Application for outline planning permission with some matters reserved for 45 No new dwellings and new access. This application also lies within the parish of Yapton. This application is a Departure from the Development Plan.

Land south of Burndell Road Ford

Thank you for your internet representation made on 8th May 2014 which has been recorded as '**an objection**' with the comments as follows:

TITLE: Proposed Access and Highway
Improvements Plan

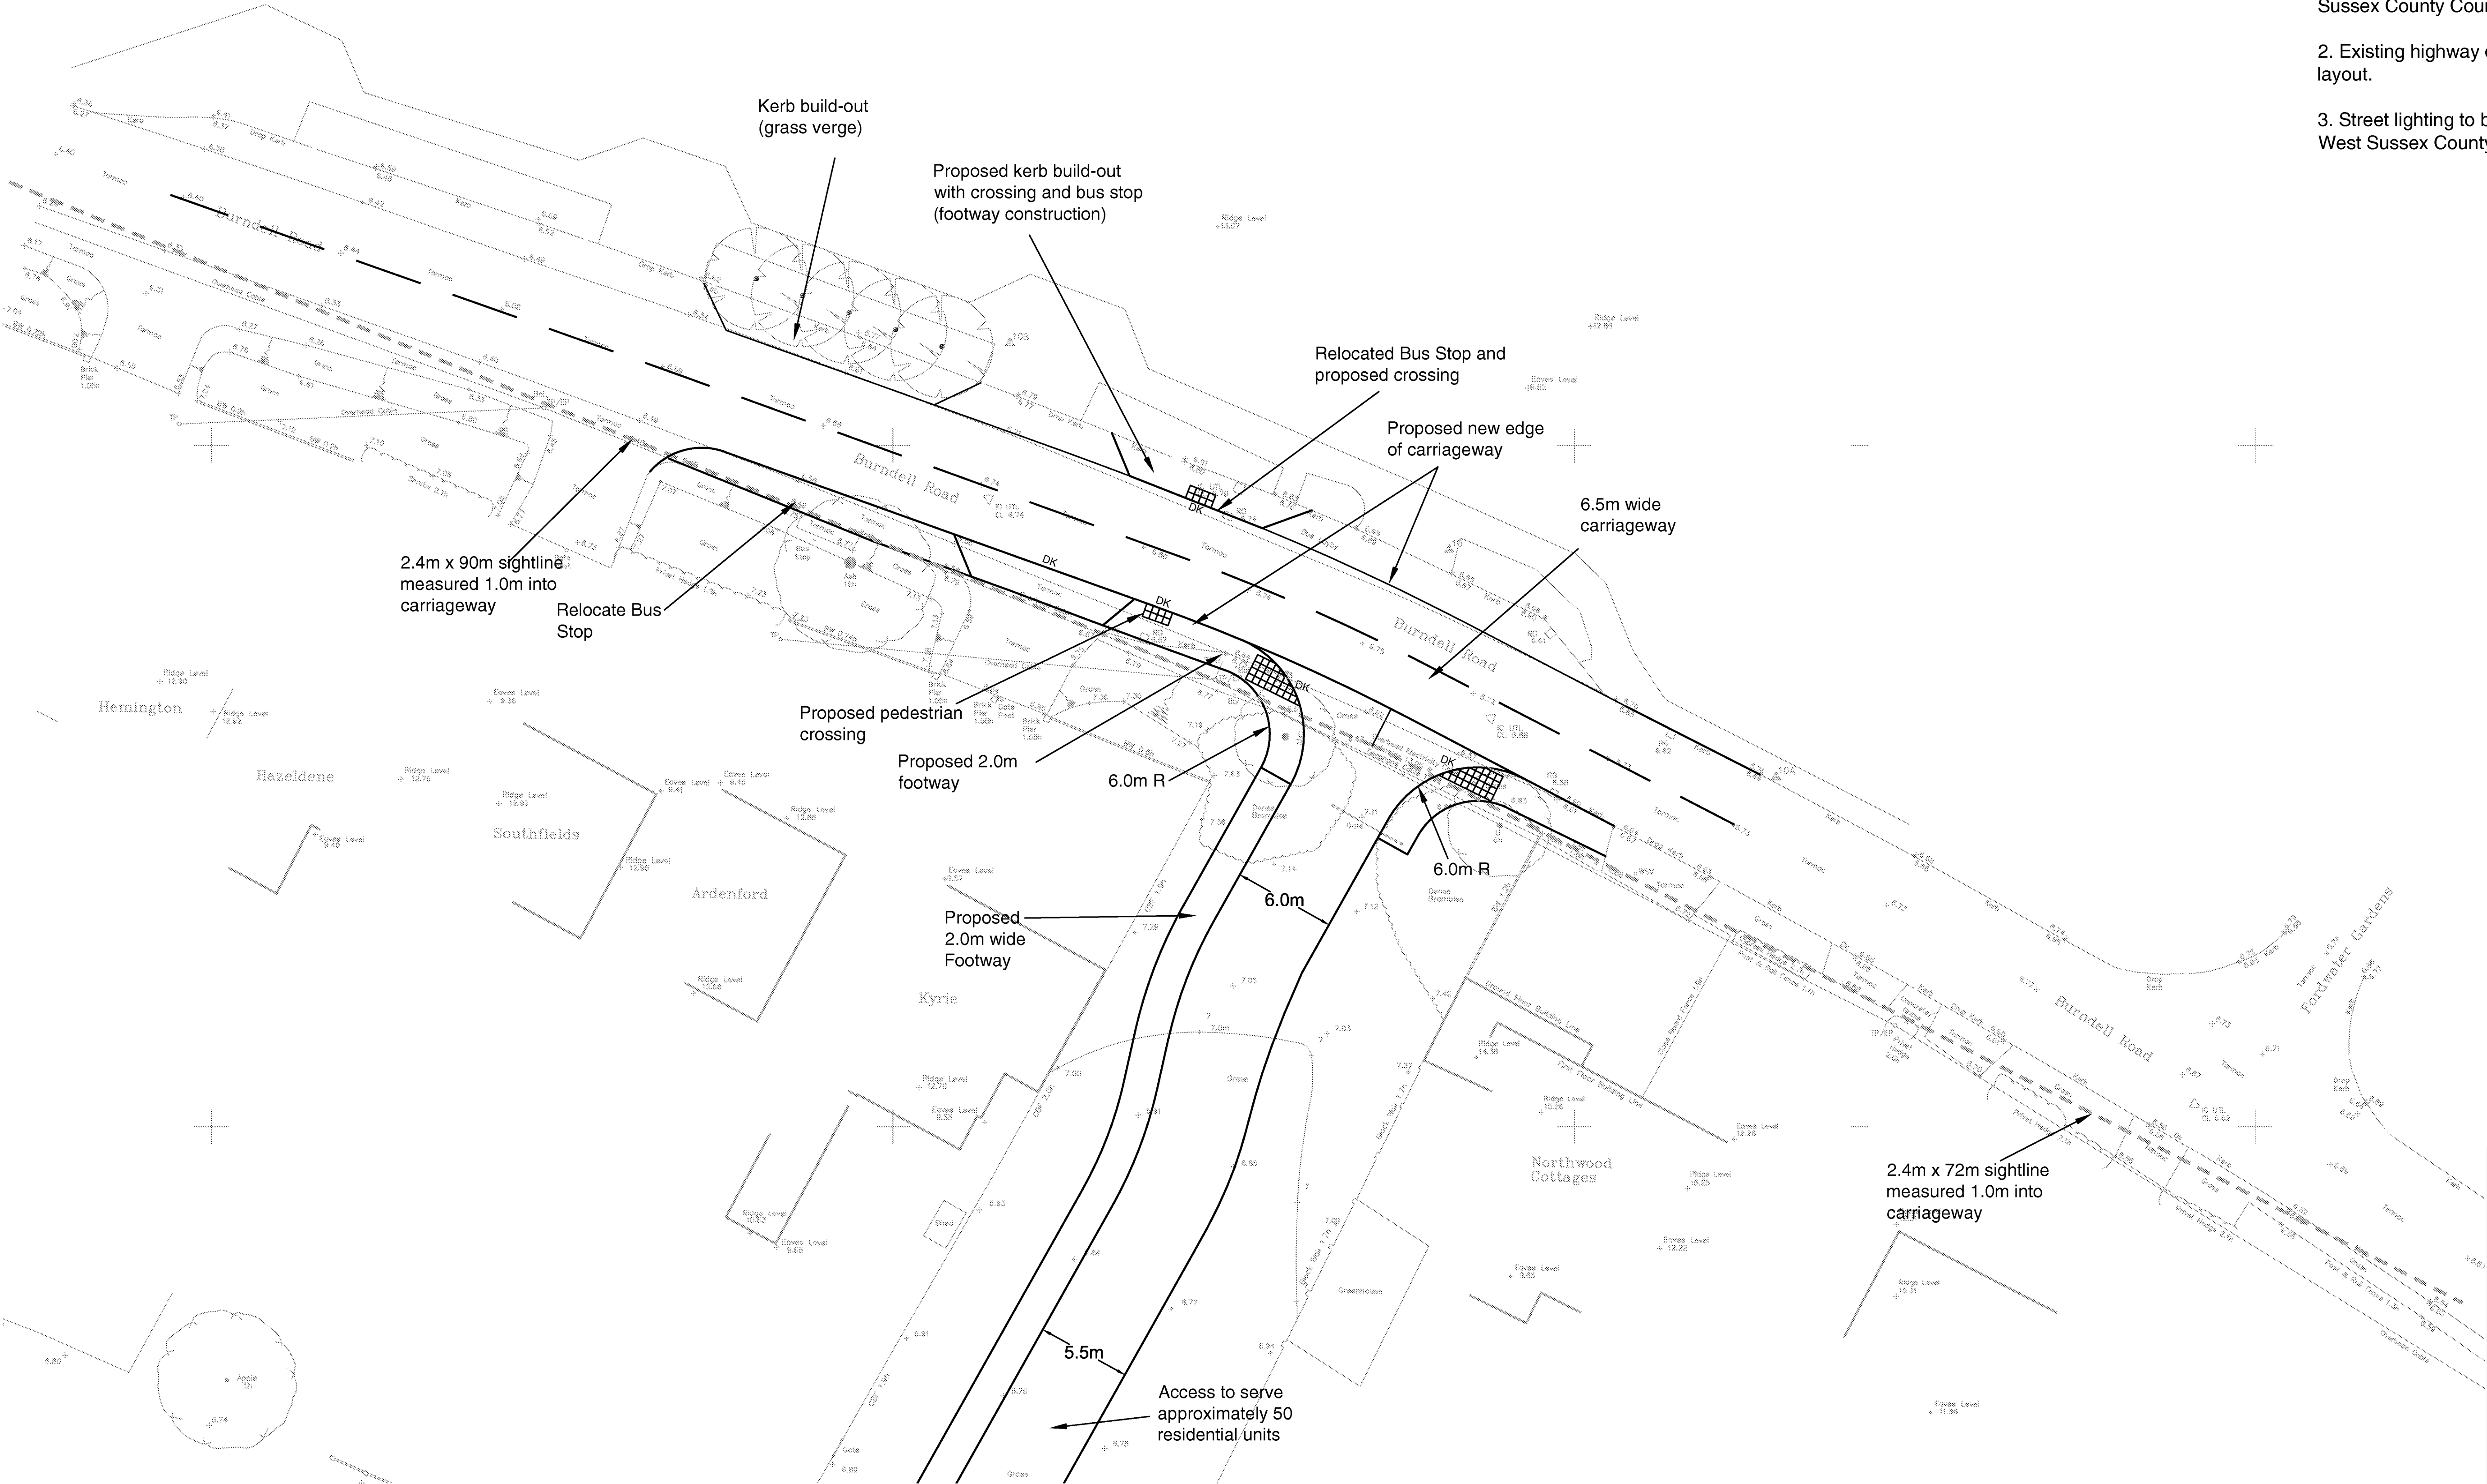
1. Road Safety-Despite the documents there is limited visibility to the right when exiting the proposed new road when viewed from a driver's position. It is noted thta the estimated average speed approaches 40mph which means that some vehicles greatly exceed this figure.

2.Narrowing of Burndell Road which restricts vehicle access to existing properties and would make entering/exiting onto a busy road hazardous.

Loss of the layby is totally unacceptable as this is used by visitors on a regular basis.
